CITY OF ALBUQUERQUE

March 12, 2021

Re: **San Roque/La Serna**
441 & 457 Coors Blvd NW
Traffic Circulation Layout
Engineer's Stamp 03-02-2021 (J10-D049)

Conceptual Traffic Circulation Layout
c5.0

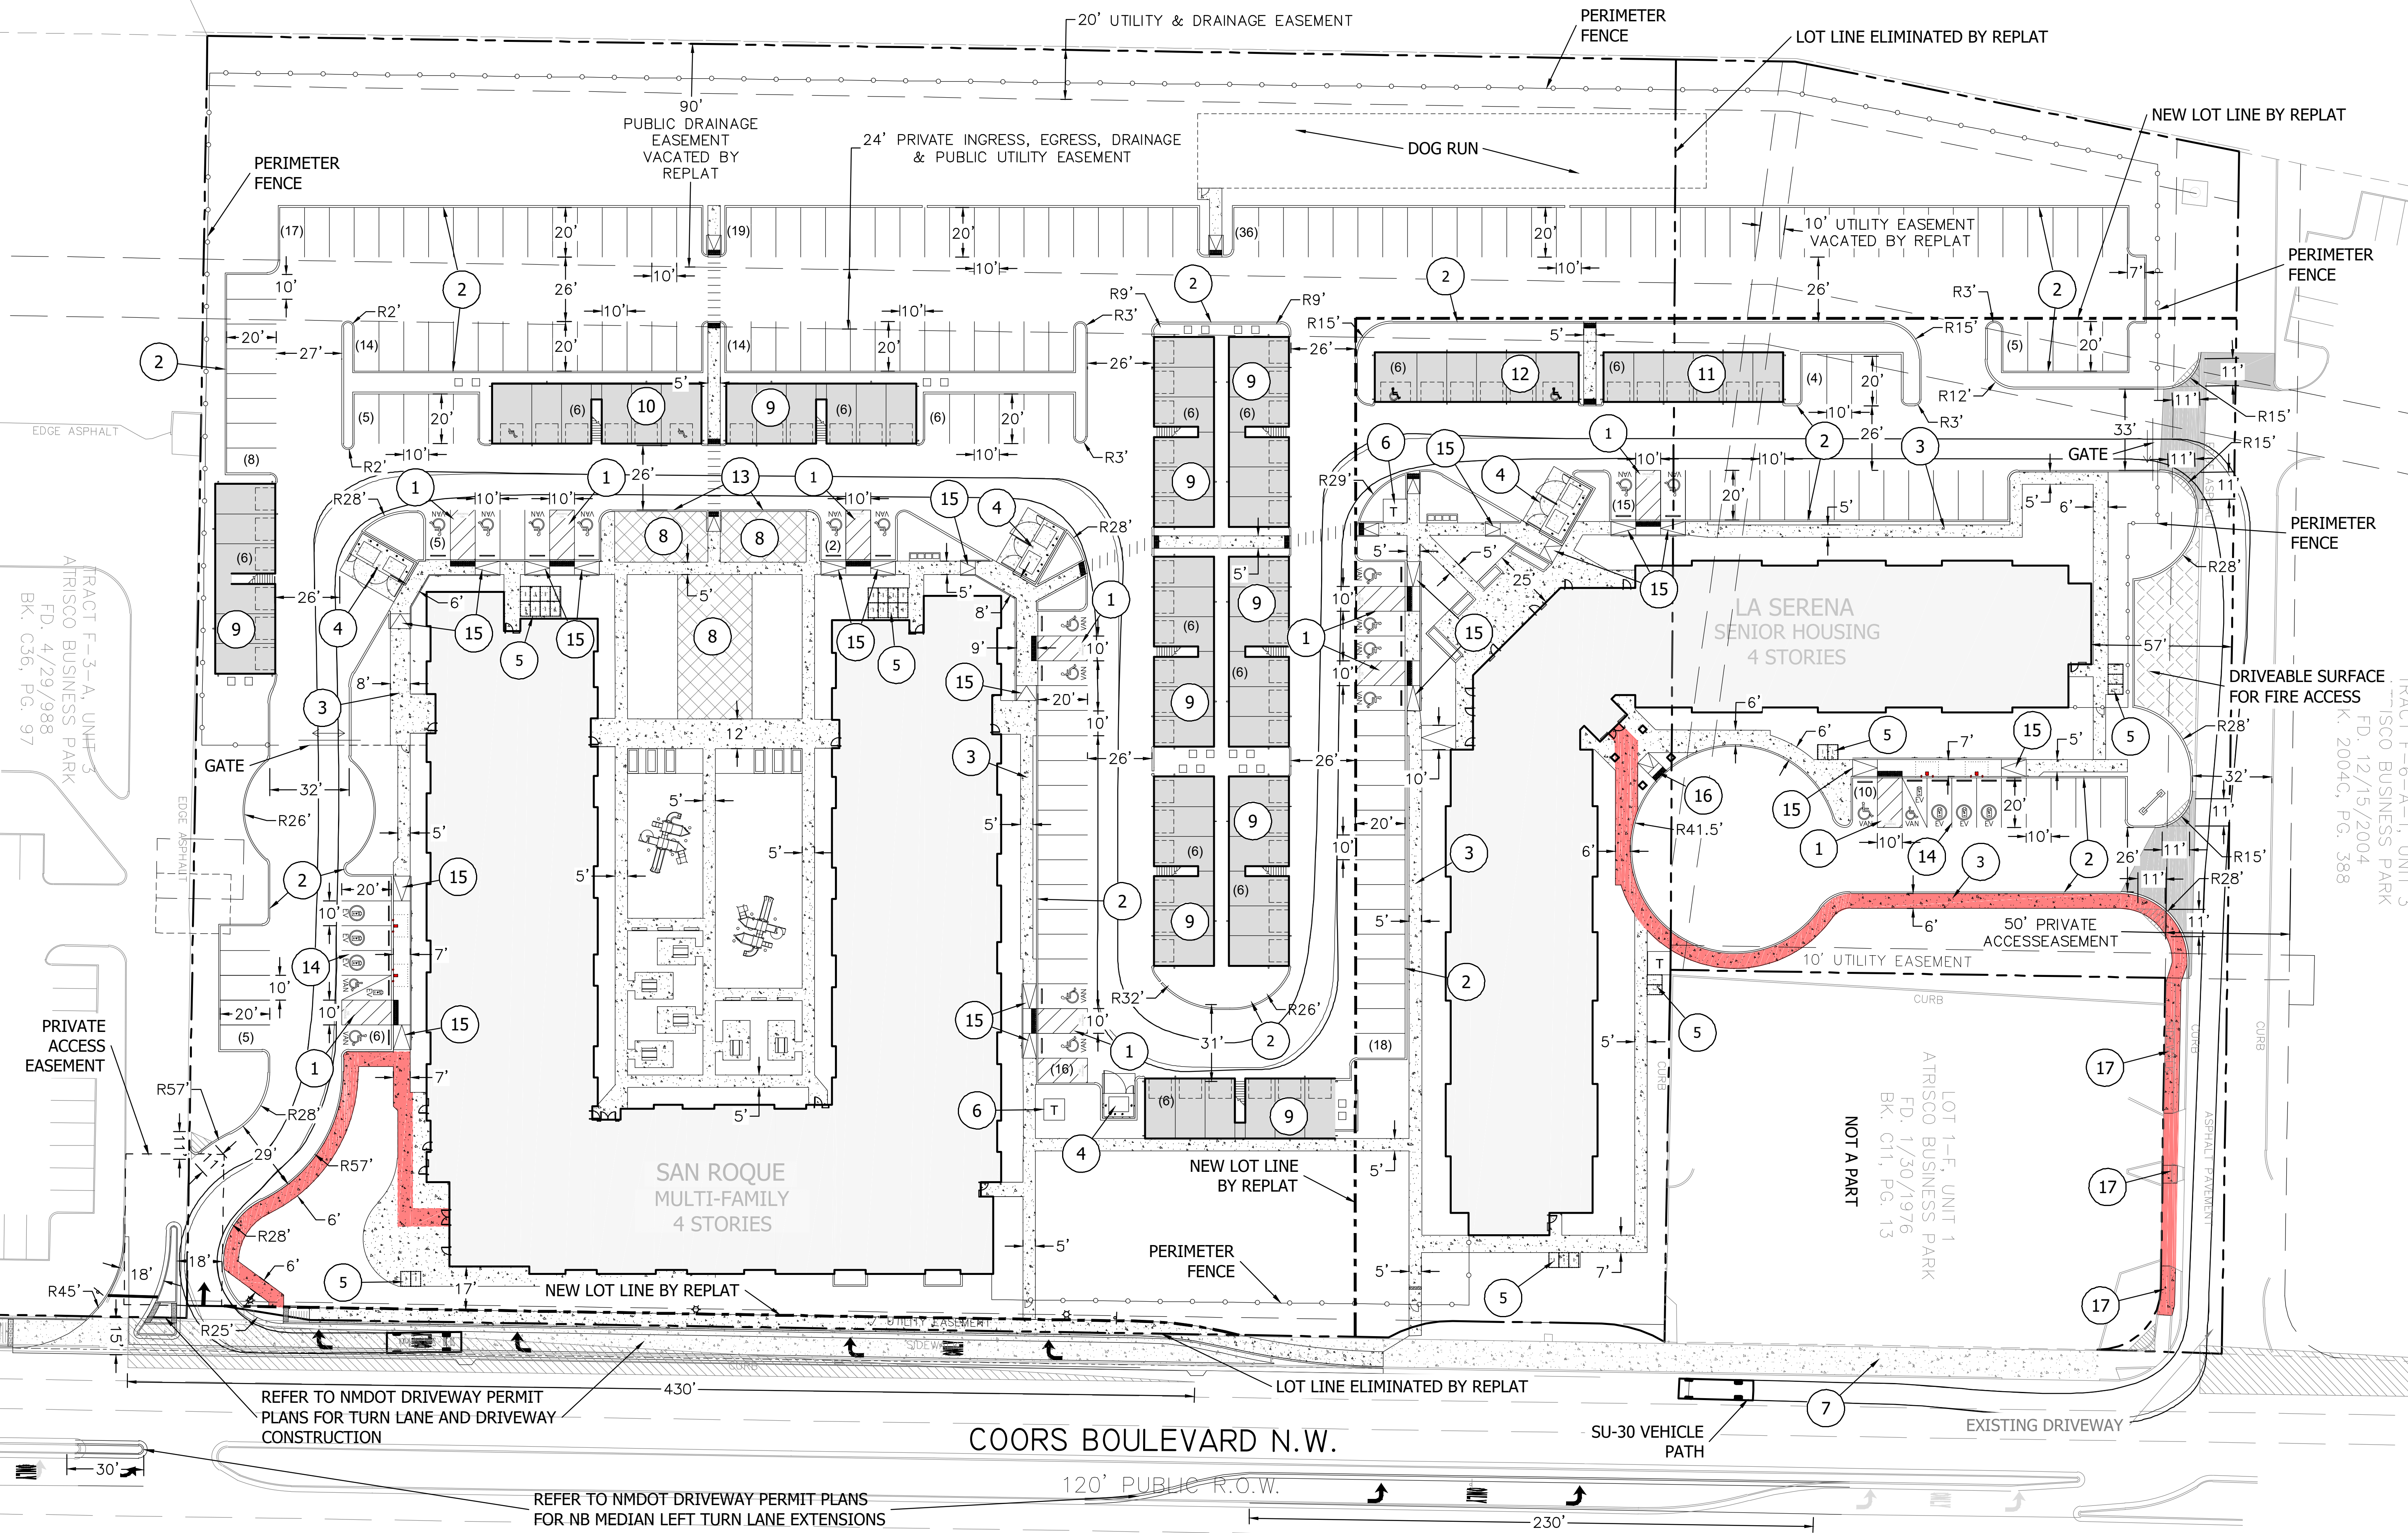
4. **Coors Blvd: All existing or proposed roadway(includes c&g, sidewalk, wc ramp, etc...) infrastructure (WIDTHS) needs to be shown on site plan.**
5. **Proposed access improvements on the south end needs construction notes to show a proper 2-way pathway onto the back of site development and an access easement from Coors onto site development.**

7. **Identify all existing access easements and rights of way width dimensions.**
8. **Identify the right of way width, medians, curb cuts, and street widths on**

9. **Please list the widths for all proposed parking spaces. Some dimensions are not shown.**
10. **The minimum parking stall dimensions are:**

11. The ADA accessible spaces must include an access aisle. Van accessible aisles should be 8ft wide; all others should be 5ft wide (**Label**).
12. **ADA curb ramps must be updated to current standards and have truncated domes installed on Coors (ramps not shown on site plan).**
13. **Ramps between buildings will need to be labeled and detail provided.**
14. **Motorcycle parking spaces shall be designated by its own conspicuously posted upright sign, either free-standing or wall mounted per the zoning code. Label pavement MC.**
15. **Show all drive aisle widths and radii. Some dimensions are not shown.**
16. **The minimum drive aisle dimensions for access pathway onto development are shown below**

17. **List radii for all curves shown; for passenger vehicles. Some are not shown(label typical if necessary).**
18. **Per the IDO, a 6 ft. wide ADA accessible pedestrian pathway is required from the public sidewalk to the building entrances. Please clearly show this pathway and provide details.**

20. **All sidewalks along streets should be placed at the property line (show and label widths).**
21. **Please call out detail and location of barrier curb. Please provide and label all proposed curbing on site. Some of them are not labeled.**

25. **Show the clear sight triangle and add the following note to the plan: "Landscaping and signage will not interfere with clear sight requirements. Therefore, signs, walls, trees, and shrubbery between 3 and 8 feet tall (as measured from the gutter pan) will not be acceptable in the clear sight triangle"**
